From: patrickprendergast@bucksplantcare.co.uk <patrickprendergast@bucksplantcare.co.uk>
Sent: 25 February 2021 11:38
To: Bob Neville <Bob.Neville@cherwell-dc.gov.uk>
Cc: Paul Almond <Paul.Almond@Cherwell-DC.gov.uk>
Subject: RE: Planning notification for application reference: 20/03660/REM

I am commenting on the above application from an arboricultural aspect.

Proposal – to build 21 dwelling at Stone Pits, Hempton Road, Deddington

REV	DESCRIPTION	APP.	DATE
 Clewsla Landscape Architecture Ltd, 17 Hempton Road, Bury, Cheshire, CH16 9RE 01293700264 www.clewsla.co.uk			
Hempton Road site DEDDINGTON LANDSCAPE MASTERPLAN HARD AND SOFT LANDSCAPE			
DWG. NO: 20_218_0010			
SCALE:	1:2000A0	DATE:	DEC 2020
STATUS:	PLANNING	DRAWN:	CC

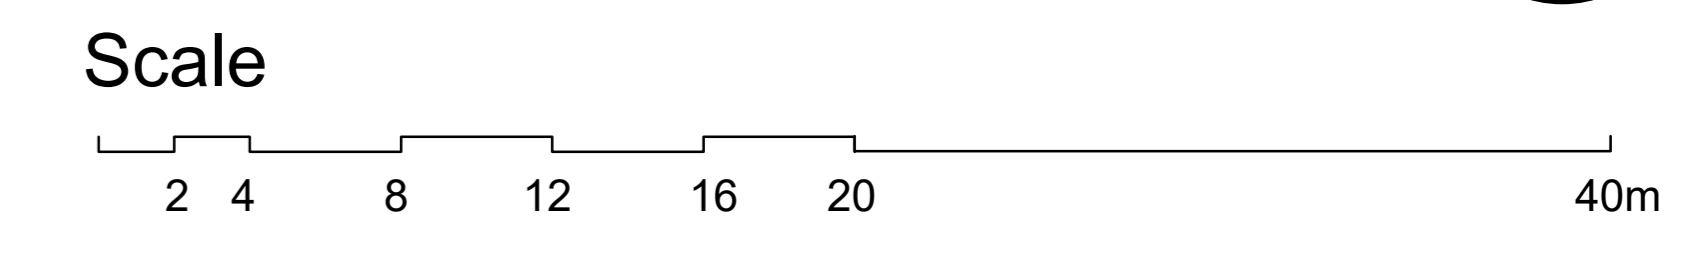
- There is a lost opportunity with regards to the landscape design to add larger growing canopy trees to improve the canopy cover
- Not sure why so many hornbeams are being used when there are other more exciting trees to choose from
- This spot is a great location for a specimen tree and a hornbeam has been proposed. It could have a nice flowering tree like a magnolia or tulip tree

- The schedule does not give the quantities of each species used
- I cannot see birch, Morus, or Prunus used on the site and only one oak tree

- There is a lost opportunity to introduce fruit trees to the rear gardens, which will benefit wildlife and aid biodiversity net gain.
- Not sure why this area on the left has not been planted with trees

- There is also a lot of hornbeam hedging where the sites could be enhanced with more ornamental evergreen hedging

So the landscape design needs a rethink so include species that will be long lived and make full use of the space. Also use appropriate ornamental trees to bring beauty and seasonality to the estate.
